23 September 2019

**UNIVERSITY OF NEWCASTLE HONEYSUCKLE CITY CAMPUS STAGE 1A (SSD-9510)  
16 HONEYSUCKLE DRIVE, NEWCASTLE**

Western Site Elevation, indicating existing residential building to the North, and future Stage 1B proposal to the South

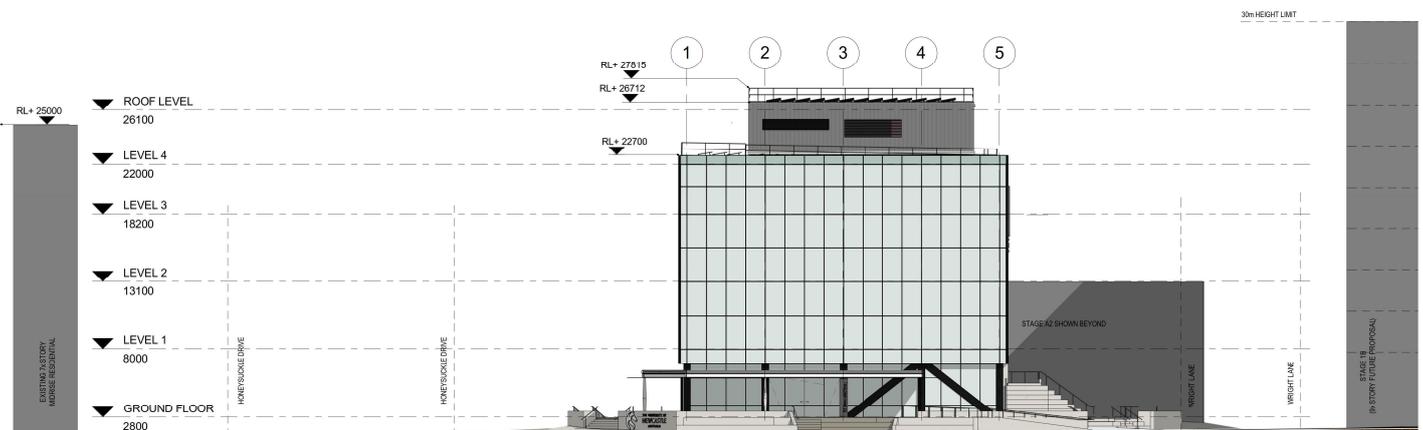
According to the Design Report prepared by EJE Architecture (Appendix A of the EIS), the western façade of the proposed building has been designed to be a '*permanent Vivid installation*' on which '*to project user generated content, representative of the buildings creative and innovative functions.*' It is not clear from the EIS as to whether these projections will be backlite or from an external projector installed on the site.

The western facade is located approximately 30 metres from several dwellings located on 10 Worth Place. The above report (Pg. 32) states that the likely visual impact of the projections on the neighbouring residences will be mitigated through '*rigorous consultation around how and when the projection can be utilised to avoid unwanted disruption and provide positive activation of the space.*' It is suggested that the applicant provide as part of the development further consideration of the visual impact on the residential properties and the measures proposed to mitigate such impacts.

Servicing and Waste **Allocations**

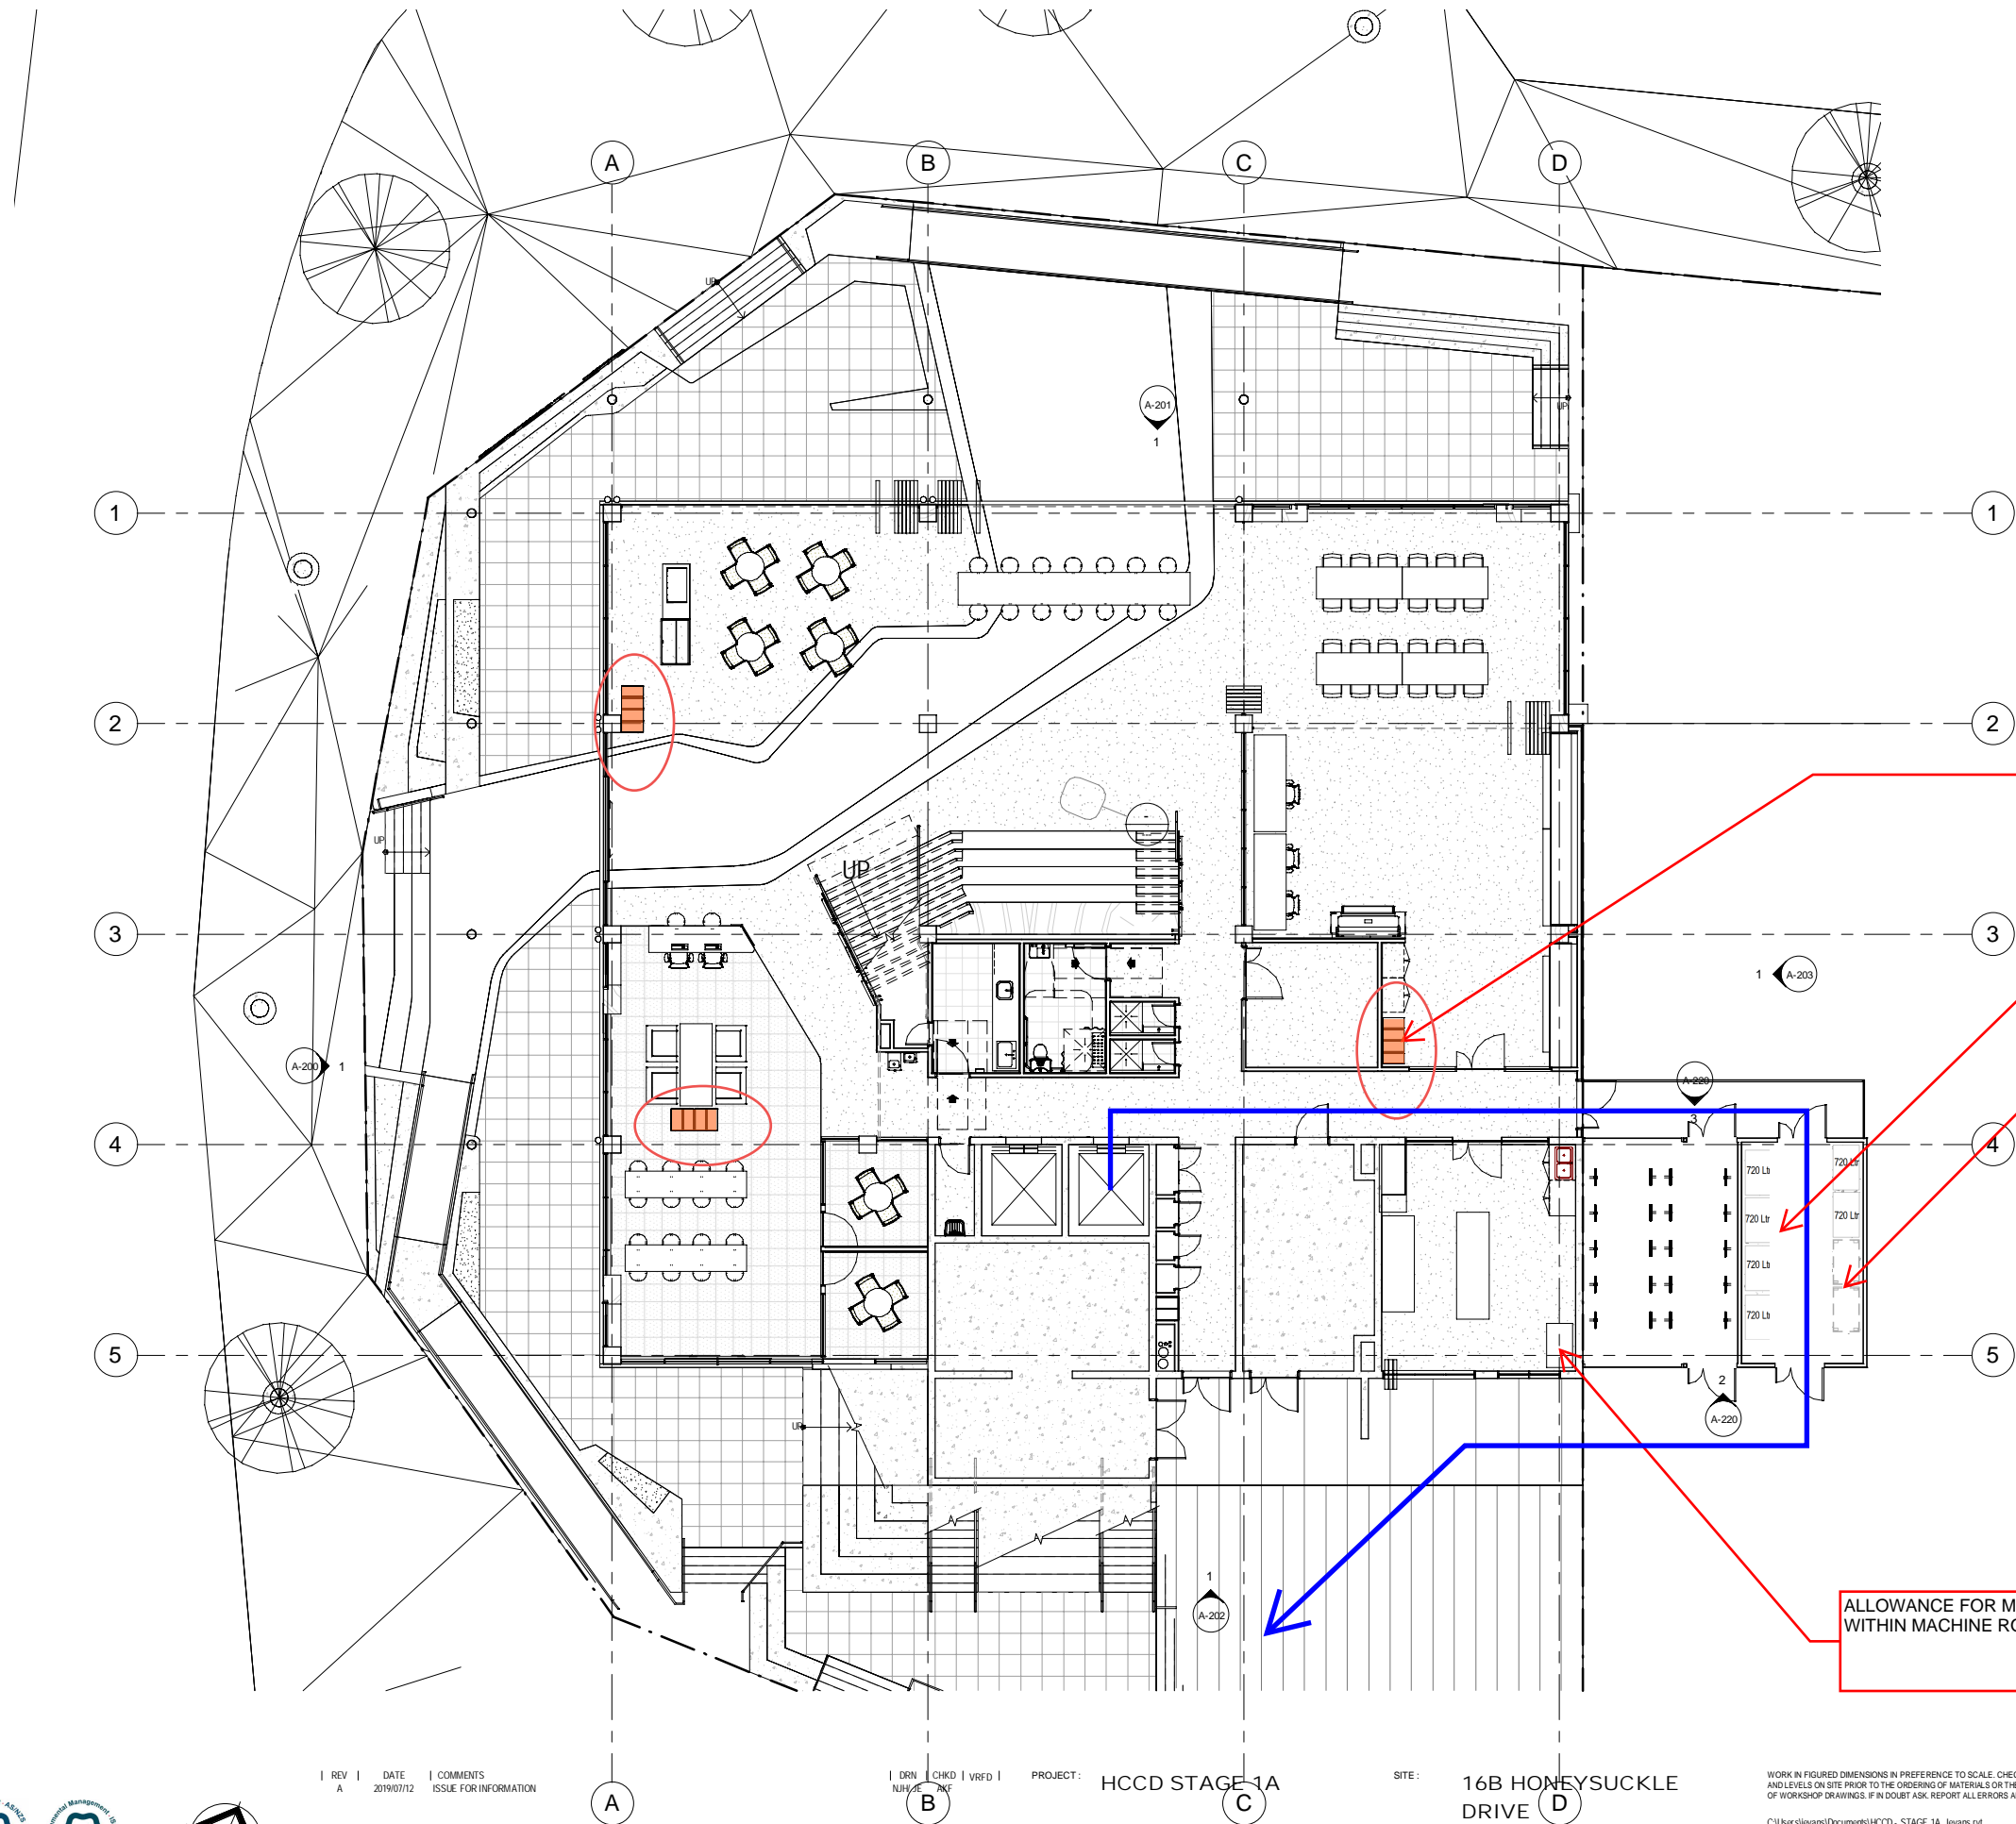
- *Whilst we have used different generation rates, largely we have reached similar estimated daily volumes, in the model not including a Café.*
- *Depending on whether the areas are utilised 5, 6 or 7 days per week will change the weekly volumes. I would suggest that to ensure adequate provision, 7-day usage be allowed for.*
- *My concern lies around whether there is to be any cafes, kitchens, food preparation areas proposed, there were none allowed for in the report and as such not taken into account for the estimation of waste generation. For example, a Café of 100m<sup>2</sup> is estimated to generate 100 litres of general waste and 120 litres of comingled recycling preday.*
- *In their Report they split waste into a number of streams, I have used only two, as we currently do not provide a food and organics collection only general waste and comingled recycling (plus green waste).*

*Depending on the service / collection frequency, I suggest they need at least 2 x 1,100 litre bins for general waste and 3 x 1,100 litre bins for comingled recycling (based on 7 day utilisation with Café, noting that if utilisation was less than 7 days, it still provides a certain amount of contingency) to allow for a weekly collection frequency, as per their plan. The footprint of an 1,100 litre bin is up to 1.75m<sup>2</sup>. Based on the specification of the Sulo 1,100 litre bins (1070mm x 1,240mm), and having 20mm between bins and a gap of 1800mm between rows of bins within which to maneuver the bins in the bin storage room (assuming 1 room), I suggest allowing for a bin storage room of 16m<sup>2</sup> (3,800mm x 3,940mm, rounded up to 4,000mm x 4,000mm). This size room also allows for installation of an additional 1,100 litre bin if necessary. If generation rates are above those estimated, additional collection services can be arranged. Doorways and pathways of 1,800mm would be recommended to allow for safe and adequate movement of bins, with no obstructions*

While the EIS (Pg26) and ground floor plan refer to a café the above Report indicates a mobile café cart. It is suggested that clarification is sought from the applicant regarding the cafe and the other matters raised by CN's Waste and Commercial Collection Manager.
